**Re: Design Review Panel – Bungarribee Industrial Estate, Metcash Proposal**

**The Panel confirms it has met and reached consensus in regards to Project Description Report – Proposed Metcash NSW Distribution Centre and associated architectural plans prepared in June and July 2010.**

## DESIGN REVIEW PANEL – BUNGARRIBEE INDUSTRIAL ESTATE – METCASH PROPOSAL

4 WH1-B&C OPTION 1 - ELEVATION 2
SCALE: 1:100 @ A1

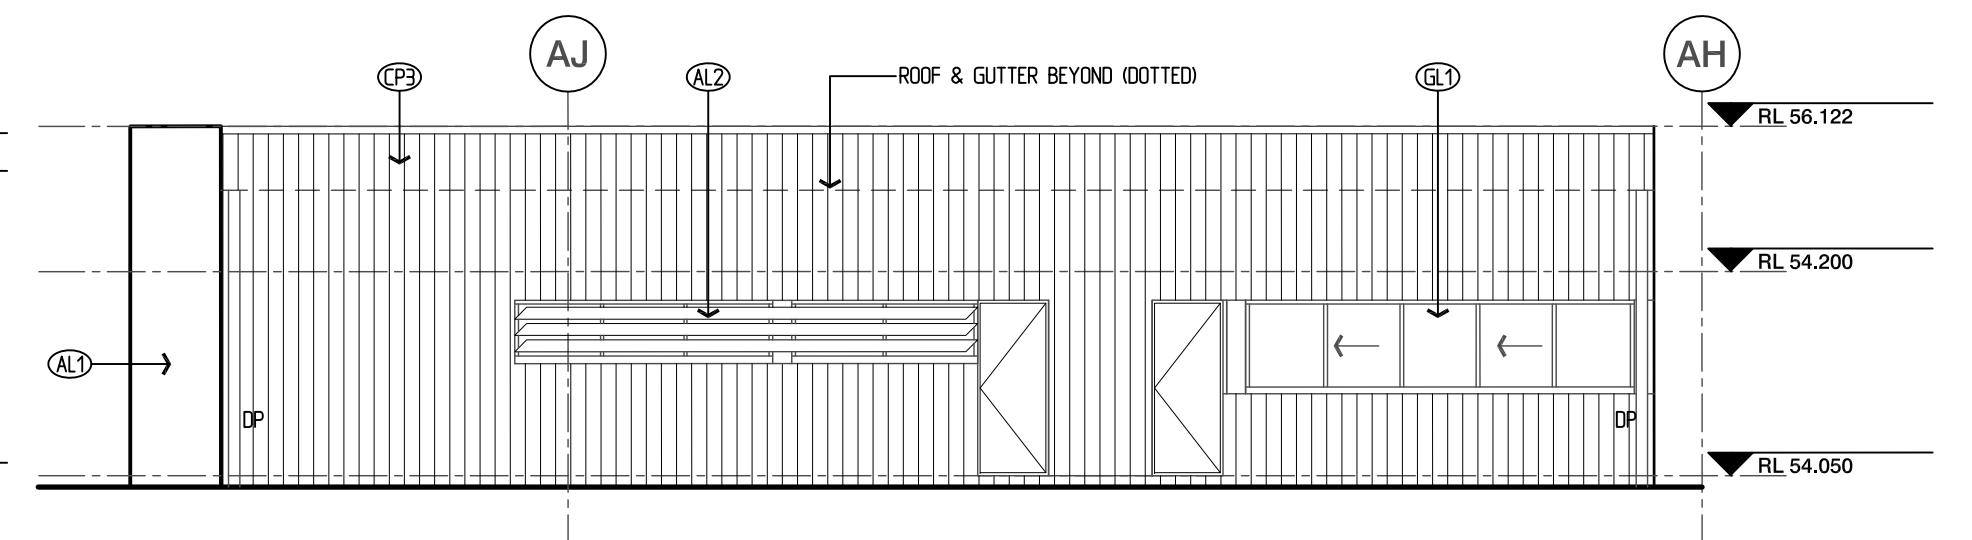
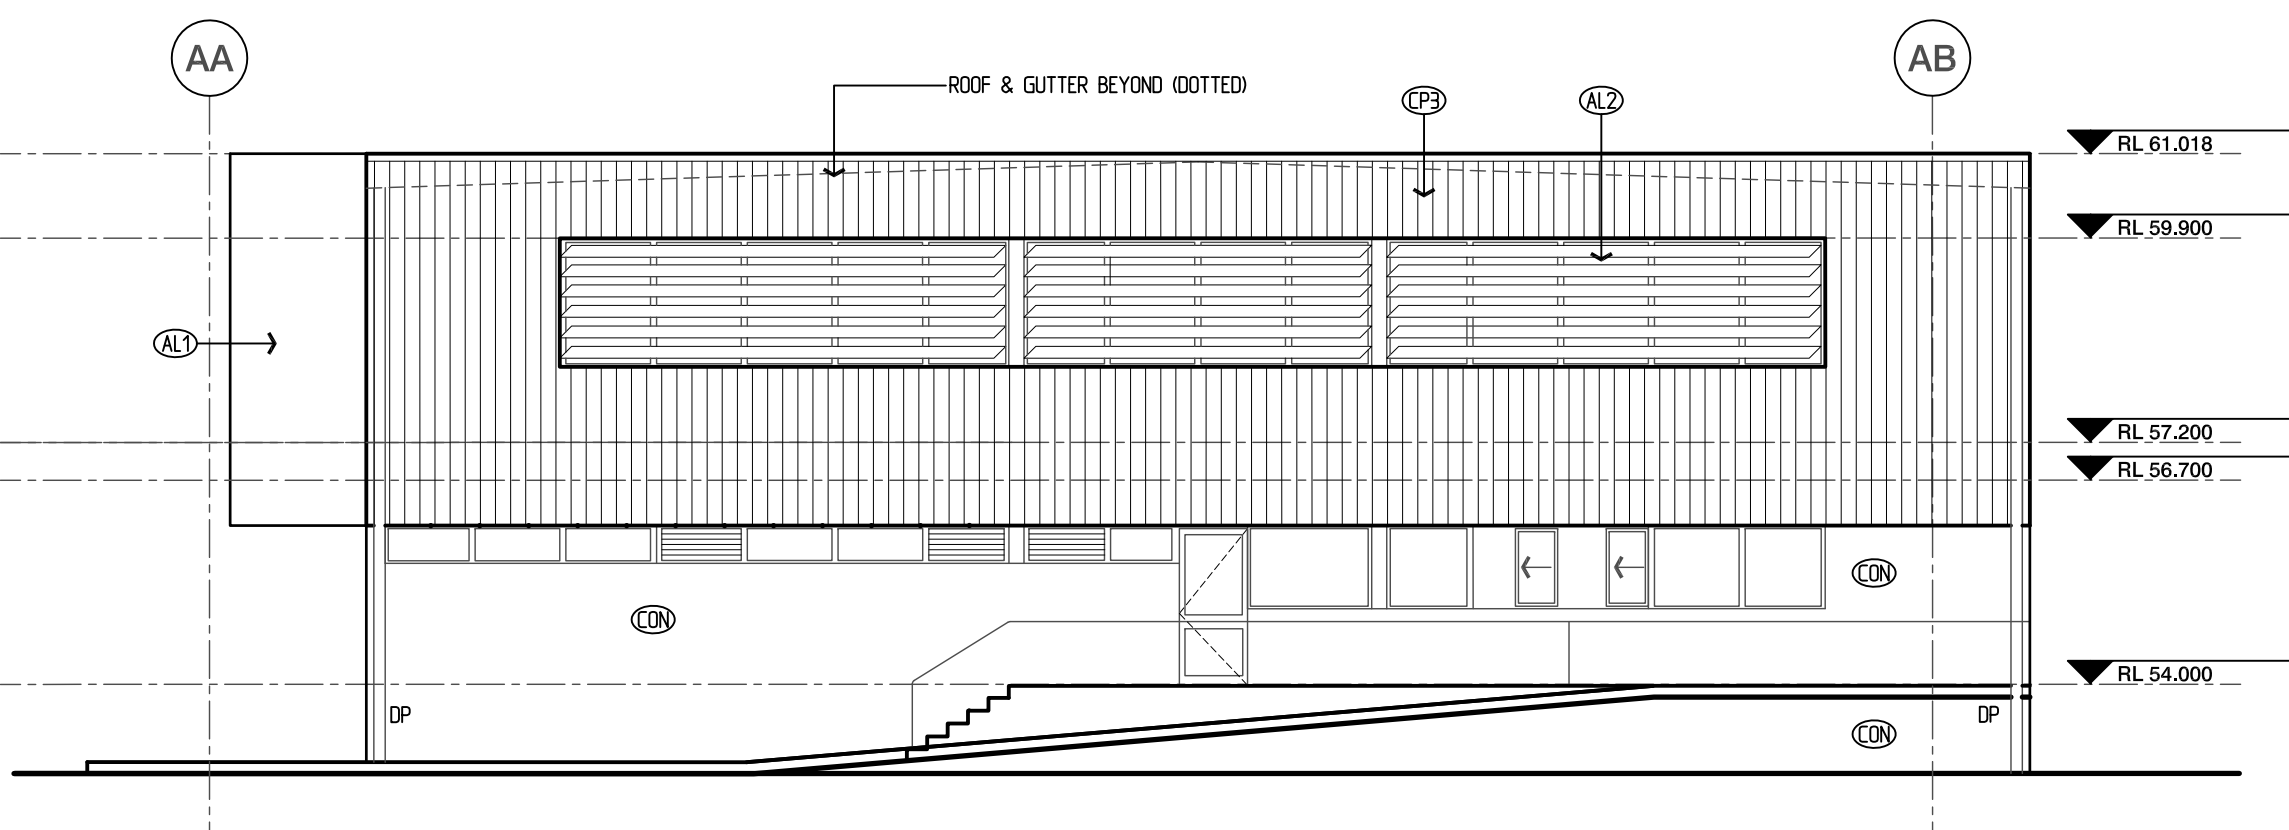
- The Panel considers that the Brabham Drive and Huntingwood Drive intersection is a major entry to the future estate. The Panel is concerned that the first built form seen as one enters the estate is the workshop/pump room/water tank that is back of house of the office area.

- The Panel would like to request Goodman to provide more architectural detail and plans as to this section of the Distribution Centre and if some design perspectives could be undertaken of this section from both Huntingwood Drive and Brabham Drive for the Panel's further review.

- It may well be necessary for Goodman to consider some design solutions to the above to assist in the visual quality of this component given its important gateway location and major entrance to the site and the Parklands.

- A final question the Panel has in regards to this component is clarification as to whether this is connected to the office area or is a separate building. The site plan shows it is connected whereas the aerial image shows it as a separate building.

<b>3. Office component and design</b>	
<ul style="list-style-type: none"> <li>The Panel complemented Goodman on the Office component design (which provides a visual break to the warehouse feel of the estate, provides an attractive street presentation to Huntingwood Drive and supports a high number of workers)</li> <li>The Panel questioned whether the office height and FSR was fixed and whether there was potential for future expansion</li> </ul>	<p>Staging plans show proposed office expansion</p>
<b>4. Workshop pump room/ water tank component and design</b>	
<ul style="list-style-type: none"> <li>Intersection of Brabham Drive/Huntingwood Drive is a major entry to the future estate and gateway to the Parklands. Therefore Panel is concerned that the first built form seen will be the workshop/pump room/water tank that is the back of house to the office area</li> <li>The Panel requests more architectural detail, plans and a design perspective of this area</li> <li>The Panel also requests confirmation on whether this area is connected to the office area or a separate building (the site plan shows it connected whereas the aerial image shows it separate)</li> </ul>	<p>The Design Team agrees the approach from the intersection at Brabham Drive and Huntingwood Drive to be of significant importance. Therefore the tank is to be screened with horizontal z-purlins on a steel support frame, this concept ties in with the louvered form of the proposed main office building. In due course the landscaped buffer zone will take form and partially screen the warehouse further.</p> <p>The Design Team considered cladding the corner with a screen of galvanised mesh, it was agreed this would be too industrial for a major entry.</p> <p>The Design Team considered cladding the corner with a screen of colorbond, it was agreed this would not provide relief form colorbond cladding each side of the tank. It was therefore decided to proceed with the horizontal z-purlins as represented on the Water Tank Sketch in Volume 2.</p> <p>The office building and the warehouse building are connected by the same concrete slab level and high level roof lights, refer to Drawing No. BIE-3A-A19 revision 2 in Volume 2.</p>
